**Heyford Park  
Camp Road  
Upper Heyford  
Bicester  
OX25 5HD**

**17/00610/REM**

**Proposal:** Reserved Matters to Approval 10/01642/OUT - Access for Camp Road Village Centre Highway Infrastructure Works. The original outline application was accompanied by an Environmental Statement.

DETAILS VILLAGE CENTRE - S278 SURFACE FINISHES LAYOUT

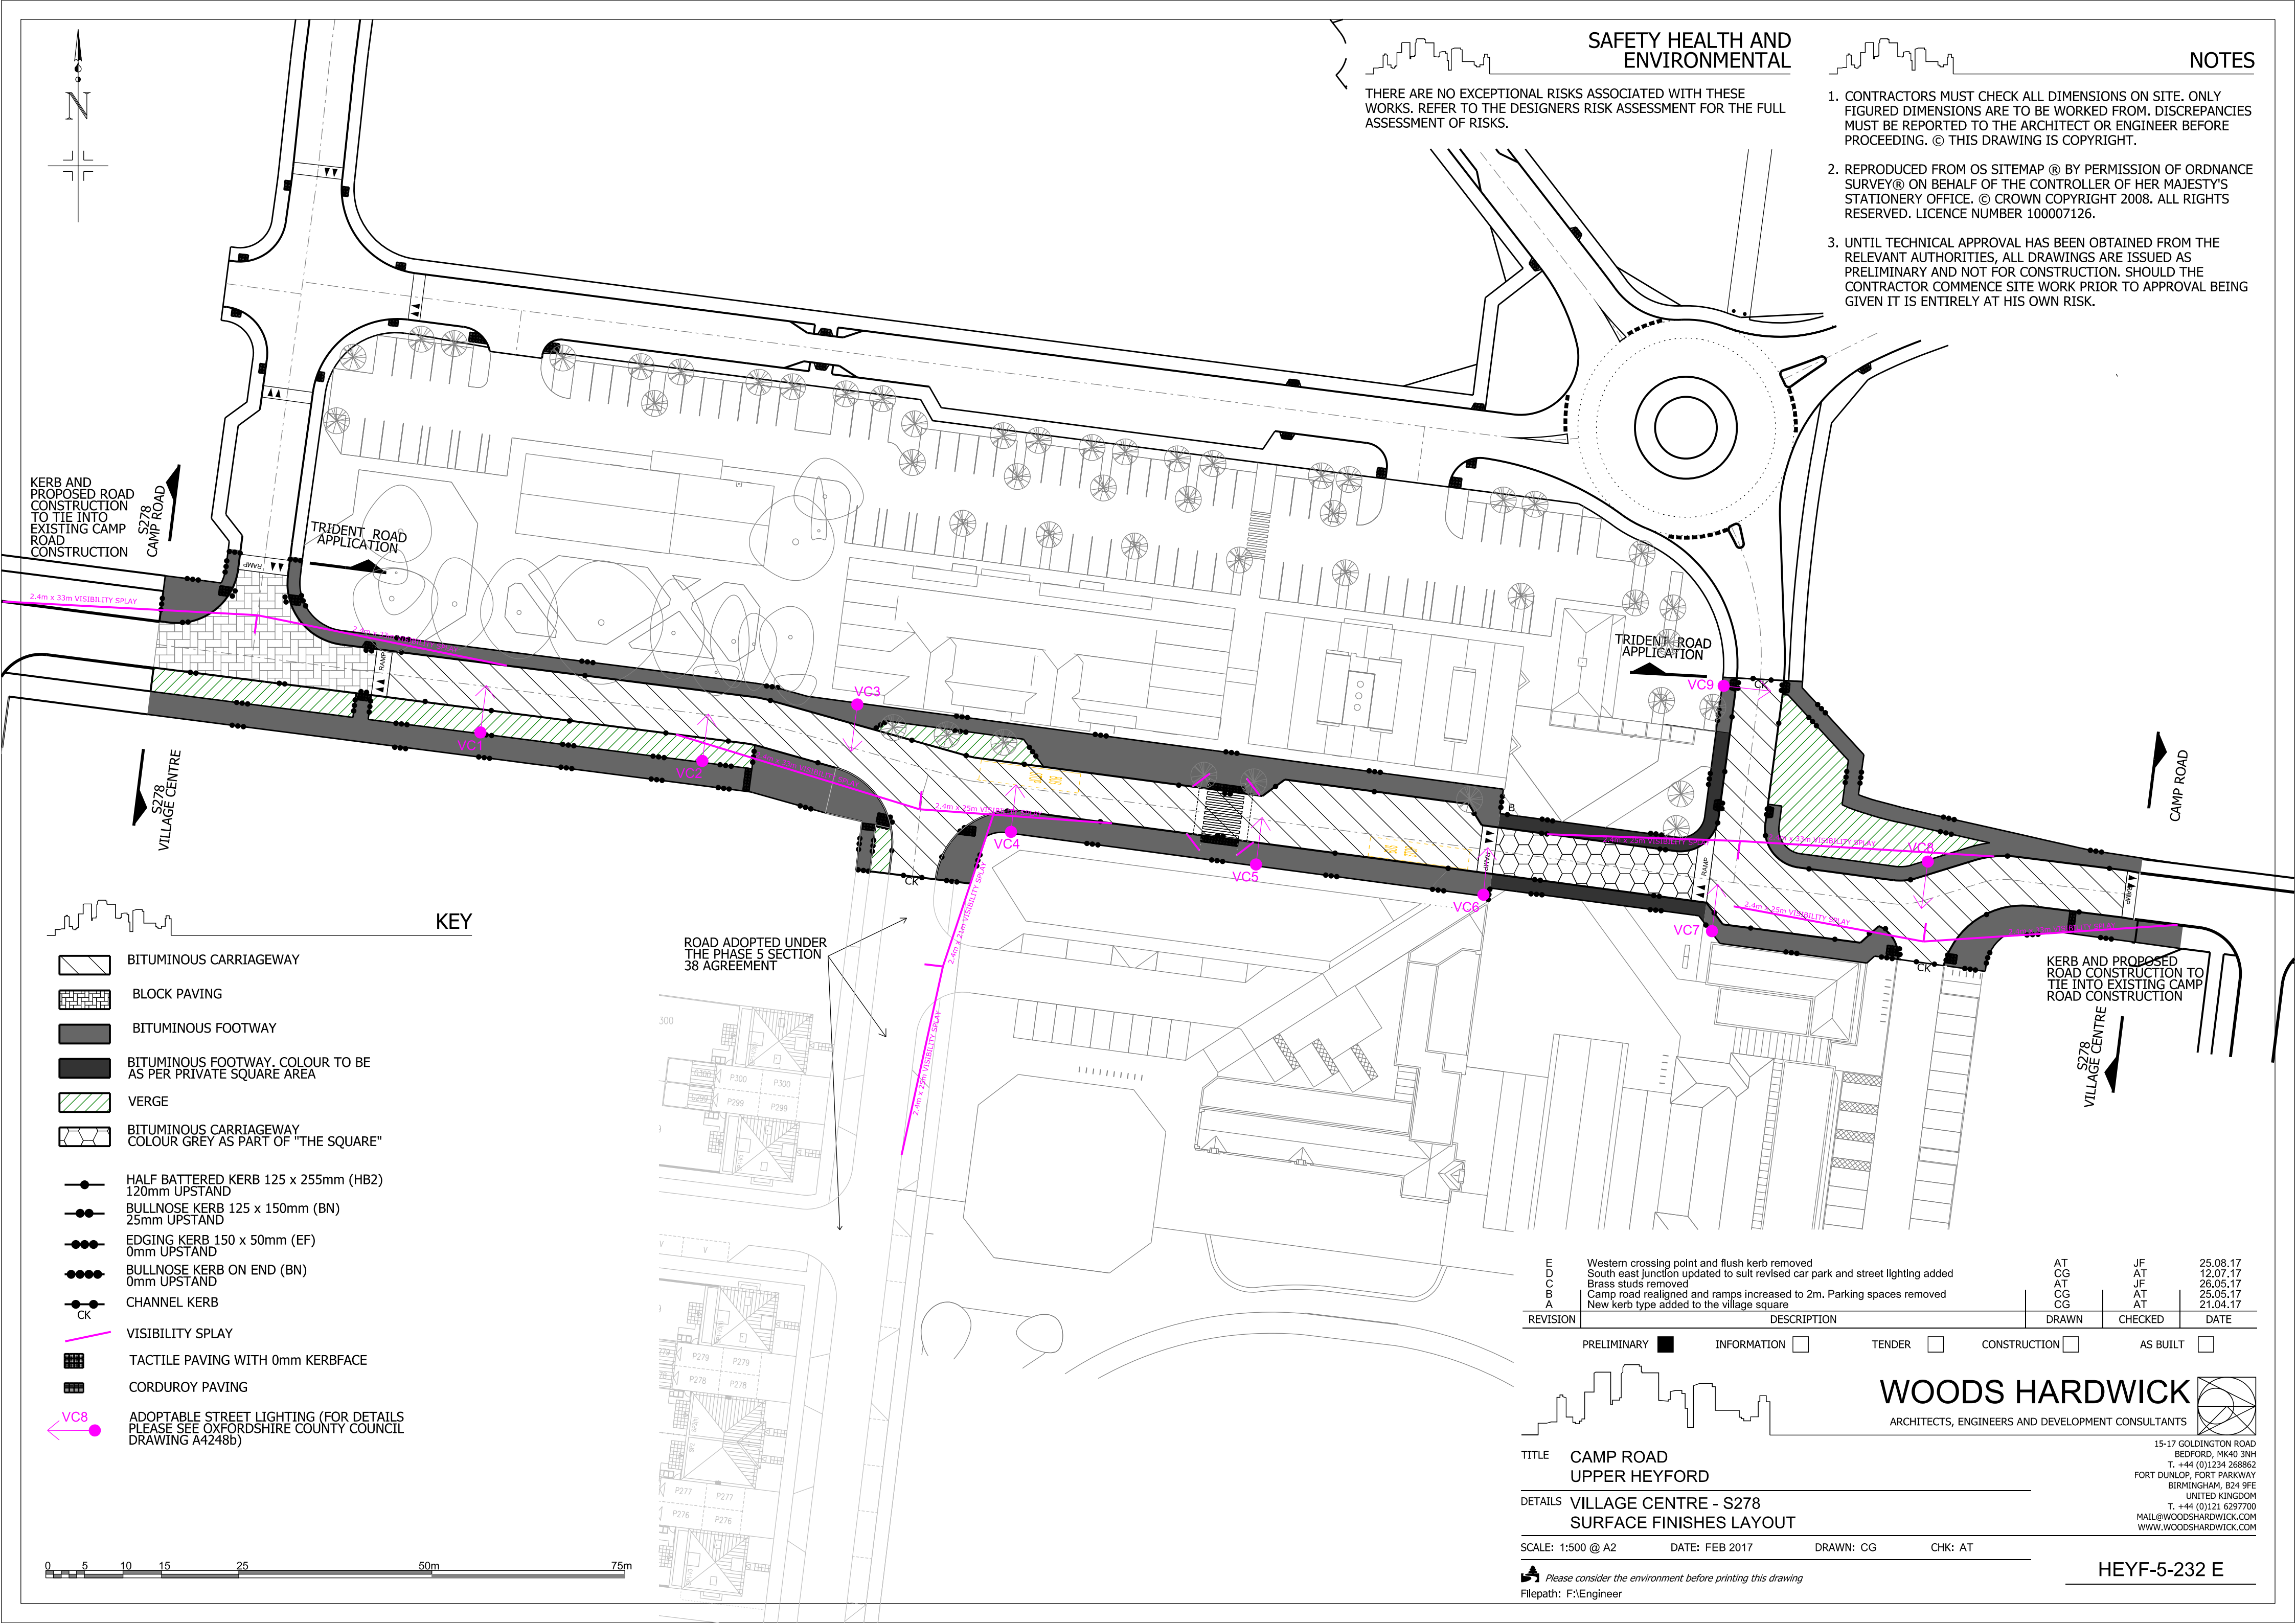
Surfacing materials and kerbs do not appear to sufficiently reflect the qualities desirable for the centre of this development. Surface finishes should be reconsidered and materials samples submitted.

- 7 No pavements other than Marshall Keyblok-Burnt Ochre are to be used in the block paved areas of the new development. No other materials are to be used until written consent of the Local Planning Authority is received for the variation.
